Application for a Non-Material Amendment Following a Grant of Planning Permission

Erection of 2 detached dwellings with associated parking, access and infrastructure (to include demolition of existing garage building and retention of existing dwelling)

22/0062/FUL

Amendment to proposed levels

CLIENT Skubala Ltd		
PROJECT Proposed Dwellings, Land behind The Mount, Cambridge Road, Cosby		
DRAWING Proposed and Existing Levels		
SCALE as noted @ A1	DATE March 2024	
STATUS PLANNING		
PROJECT No. 23/402	DRAWING No. 23/402 LV01	REVISION /

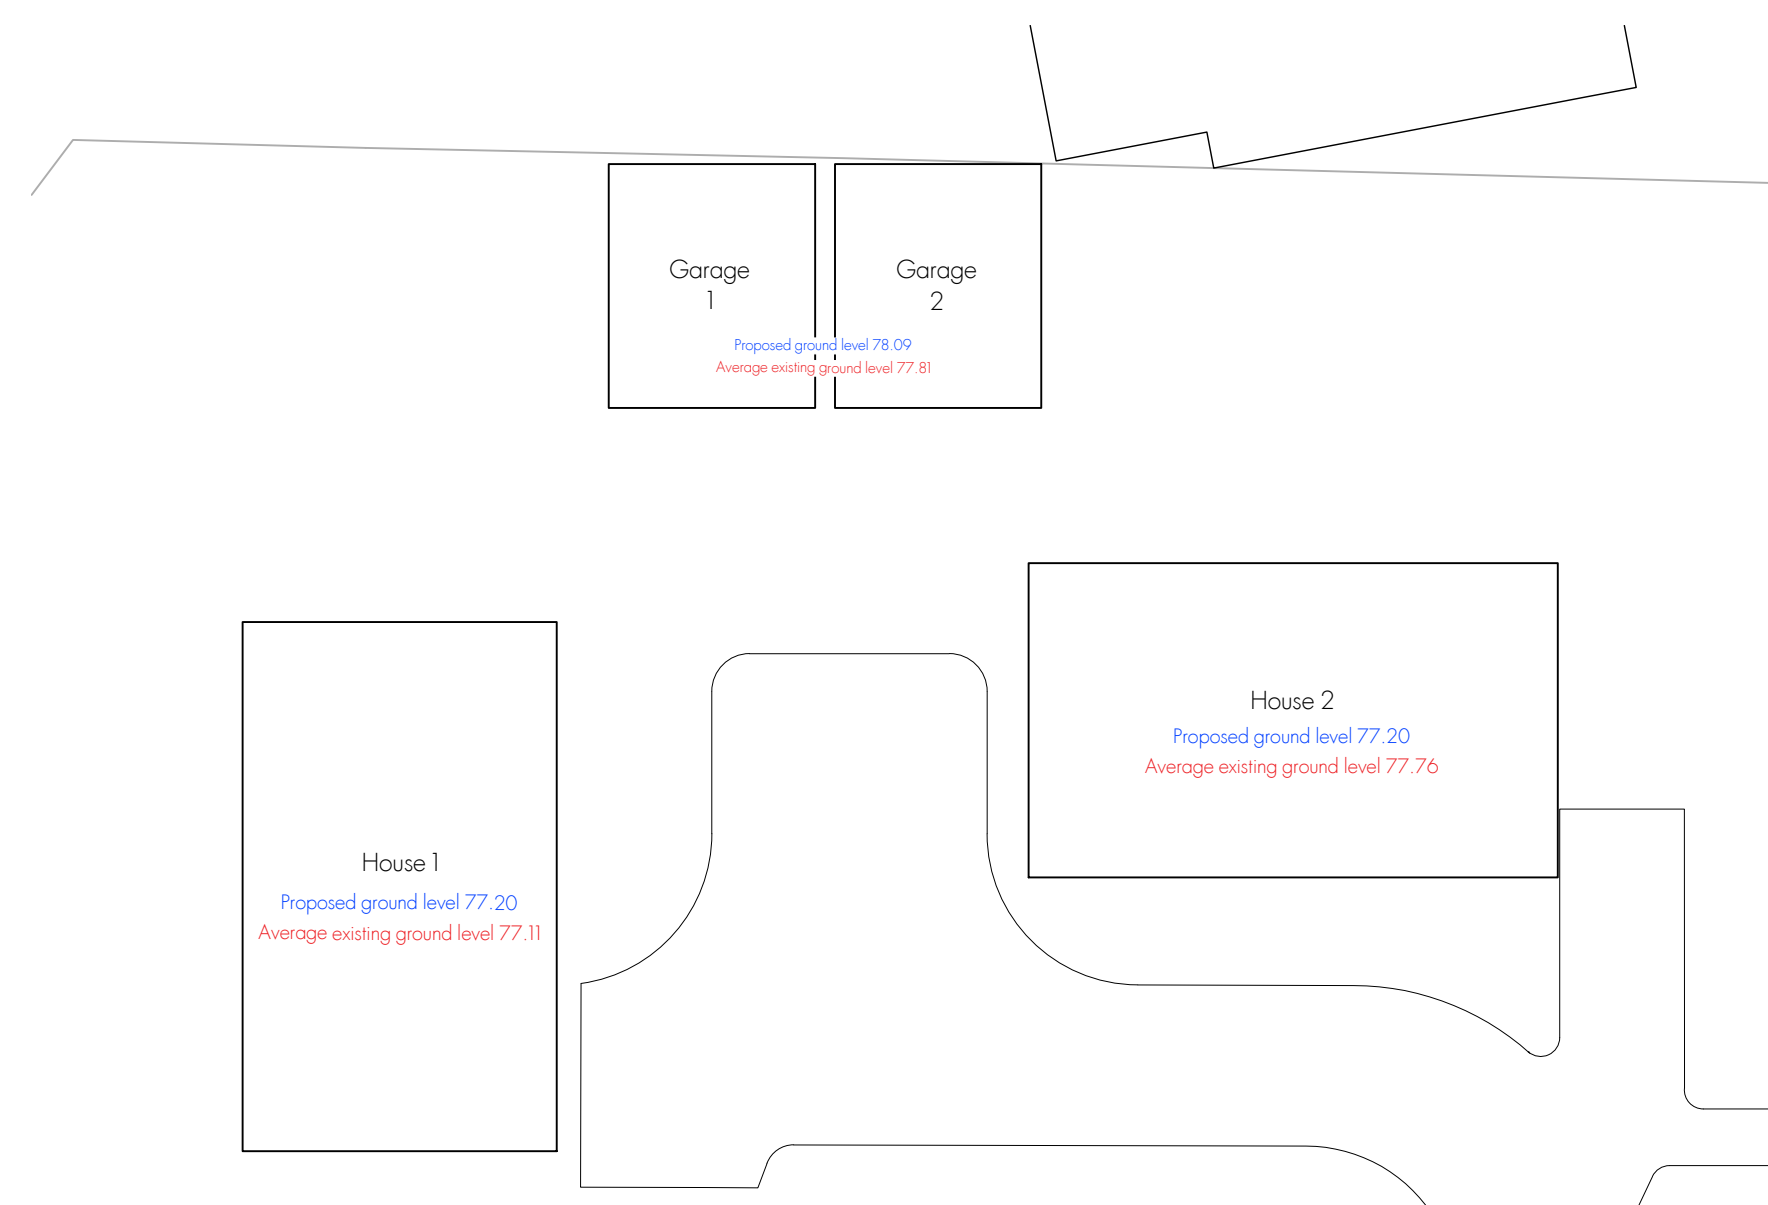
The original application was submitted without reference to the relationship between the proposed dwellings and the existing topography. An indicative street frontage elevation (drawing ref. 0308 PL-204) formed part of the approved drawing package but it does not reflect the actual site levels.

After investigation it has become apparent that to provide the dwellings at the heights indicated on the approved drawing, a significant reduction and increase of existing ground levels would be required. On the above mentioned approved street frontage drawing, house 1 is sited 700mm higher than house 2, whereas the ground is lower on the site for house 1 and higher on the site for ground 2.

Ideally the approved proposed house levels would be amended so that house 1 is at the lower level and house 2 at the higher level in order to correspond exactly with the existing topography. However, for simplicity we are proposing to reduce the level of the house 1 and raise the level of the house 2, making them the same height which would reduce the degree of disturbance of the existing site and in turn reduce the impact on biodiversity and natural eco systems.

Please note that the dimensions of the proposed buildings have not been amended.

For reference existing site levels have been indicated on attached drawing 23/402 LV01.

23/402 LV01
